Application No: SSD 13_6123

Campus Improvement Program 2014-2020 for Camperdown-Darlington

Response to RtS for SSD6123

Date: 25 August 2014

01 DARLINGTON TERRACES - ELEVATION FROM CODRINGTON STREET PROPOSED

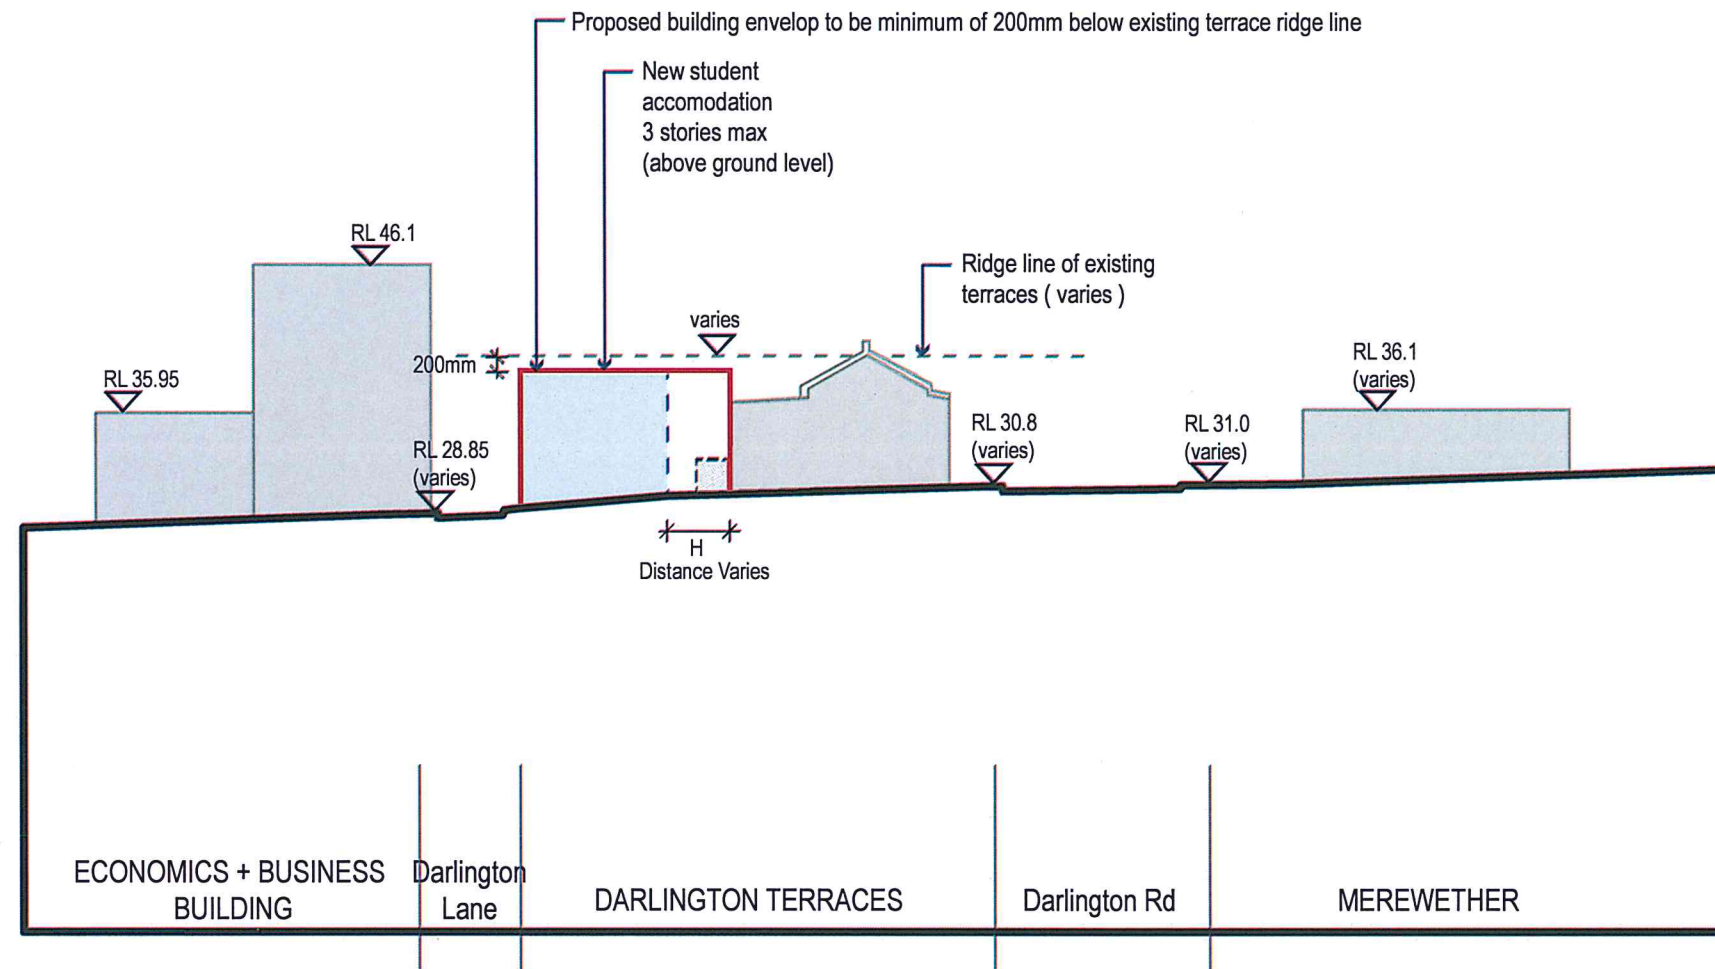
I object to the University's proposal to completely infill the backyards of every heritage listed terrace house (bar three) from 86 – 130 Darlington Road with three storey extensions. I understand that the National Trust has given these terraces an "A" rating – "highly intact". The University will have used almost every piece of land for its development, leaving very little open space, vegetation or light, all of which are important to the health and wellbeing of the people living in the area. The University should not be allowed to degrade the heritage value of these terraces which are very close to the Golden Grove.

01 ENGINEERING - SHEPHERD STREET ELEVATION PROPOSED

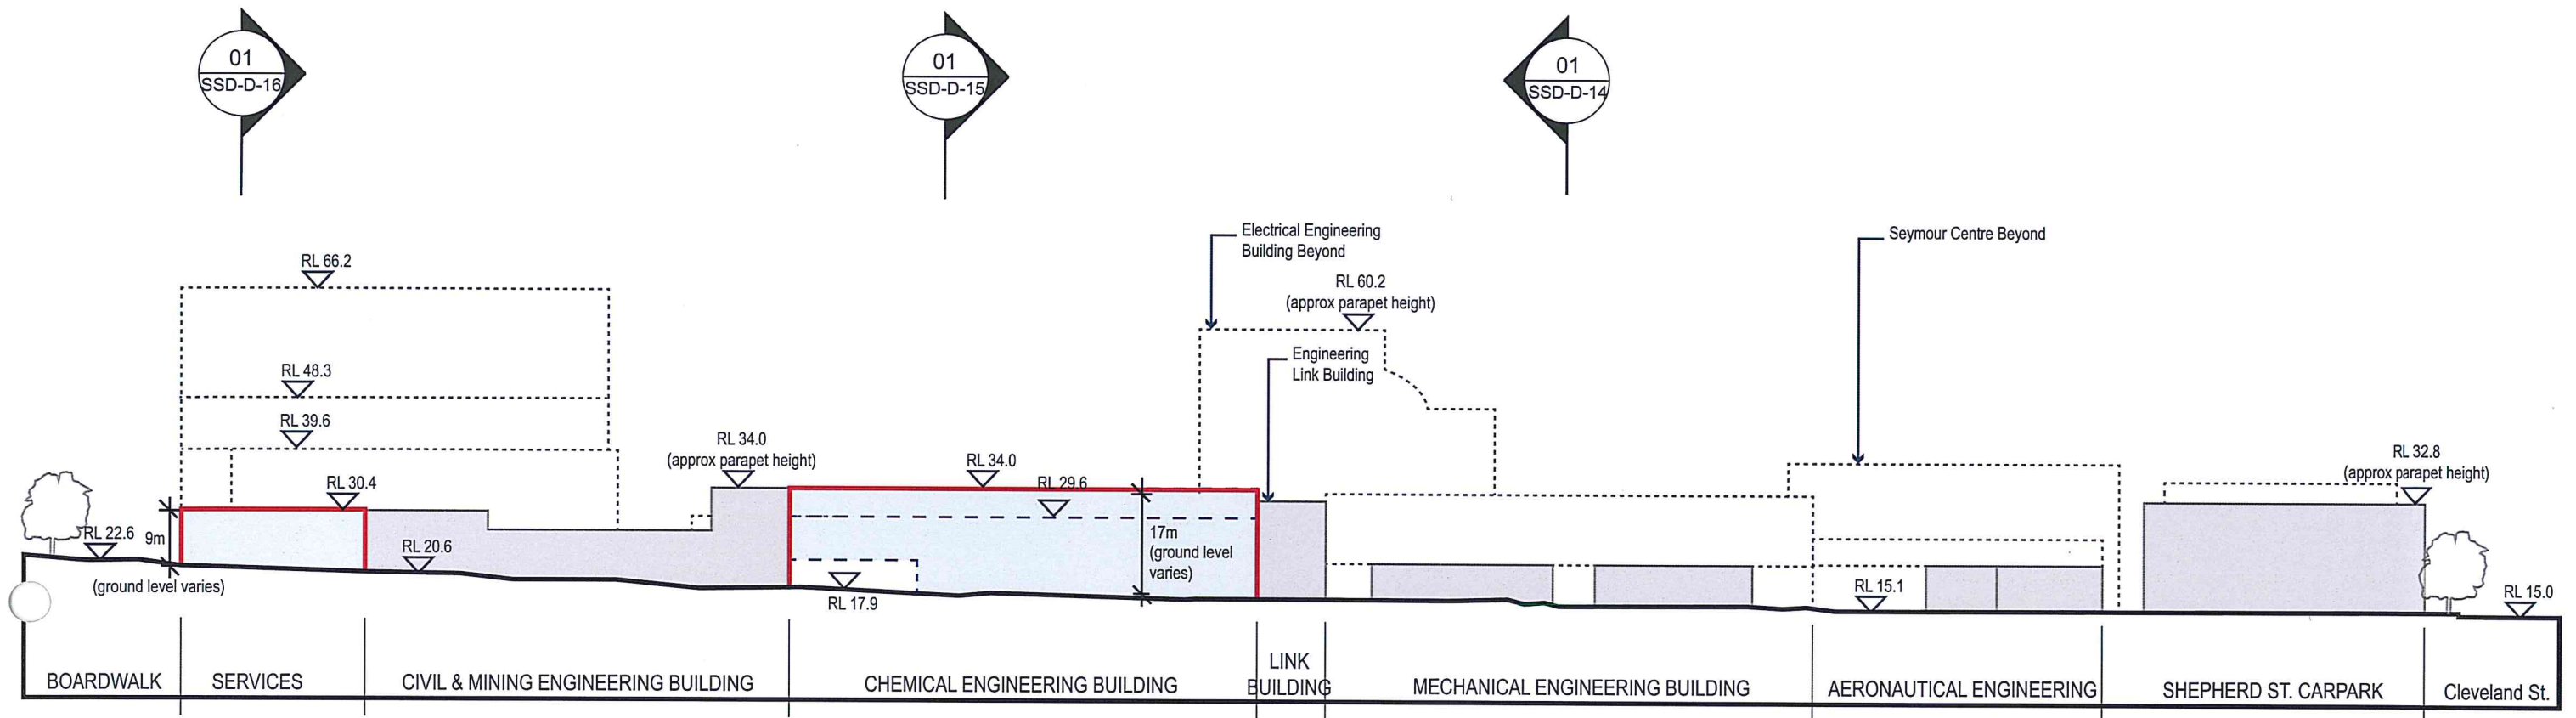
I remain opposed to the proposed Service Centre on Shepherd Street. I understand the rationale behind having principal Service Centres but repeat the suggestion that a more appropriate location for it would be near the intersection of Shepherd and Cleveland Streets.

This would mean that heavy service vehicles could enter and exit from the main arterial road of Cleveland Street and would therefore be kept off residential streets. This would ensure less noise and congestion in Shepherd Street.
